Arun District Council
Arun Civic Centre
Maltravers Road
Littlehampton
West Sussex BN17 5LF
Planning & Building Control General Enquiries
Tel: (01903) 737756 Fax: (01903) 730442
Dx: 57406 Littlehampton
Minicom: 01903 732765
e-mail: planning@arun.gov.uk
website: www.arun.gov.uk/planning

Your Ref: LU/32/12/DOC

Article 21 of the Town and Country Planning (General Development Procedure) Order 1995
Application for approval of details reserved by condition 5 & 6 of previously approved planning
application LU/350/11
Millfield Rest Home 9 St Catherines Road, Littlehampton,

Proposed parking for cycles AND MOTOR VEHICLES

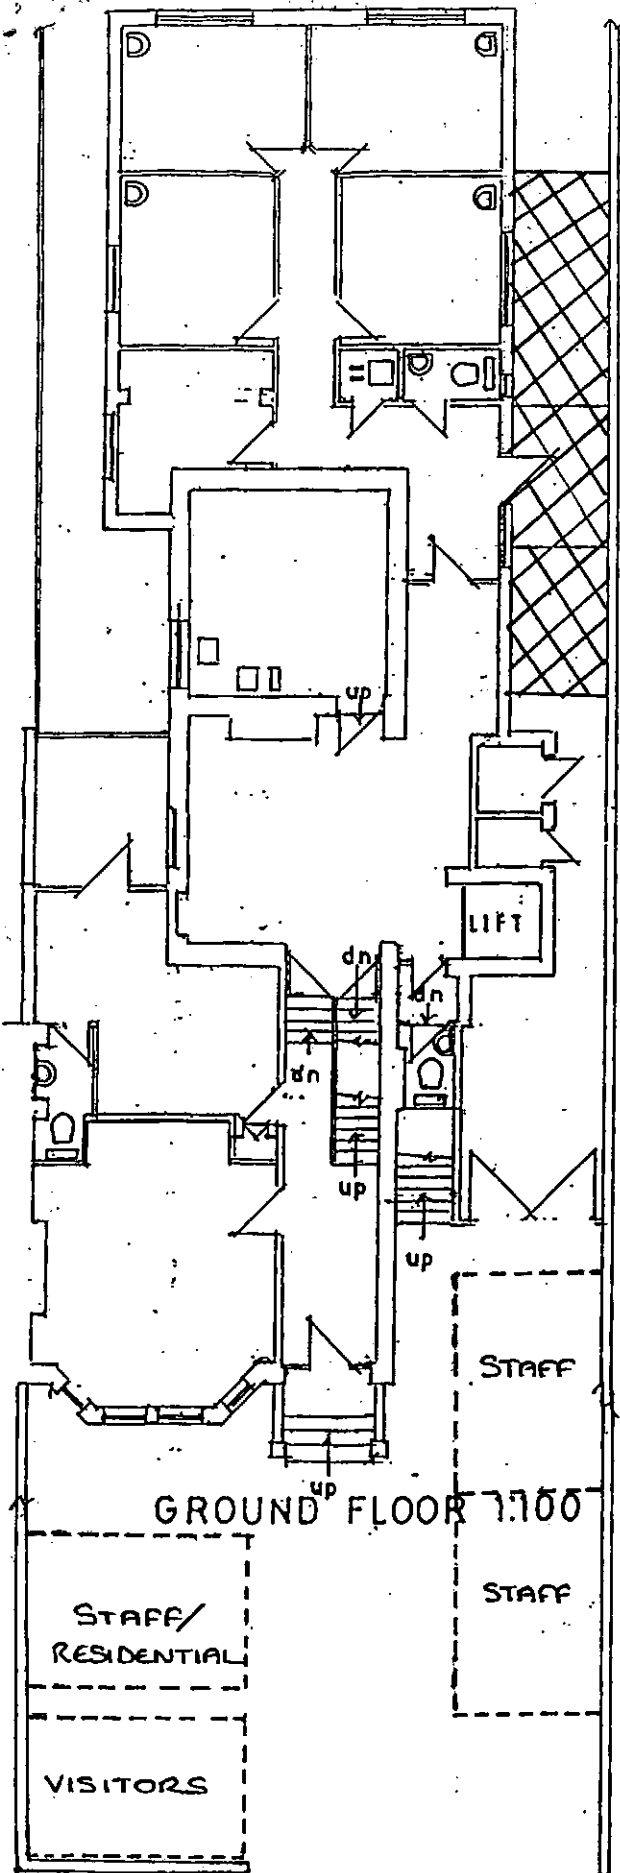
Arun District Council have decided to **APPROVE details reserved by this condition**
West Sussex County Council Highways have confirmed that the proposed cycle parking provision is sufficient, providing space for at least 4 cycles, therefore in accordance with Drawing 1 (Proposed parking for cycles and motor vehicles) the condition is discharged in so far as the submission of details relate.
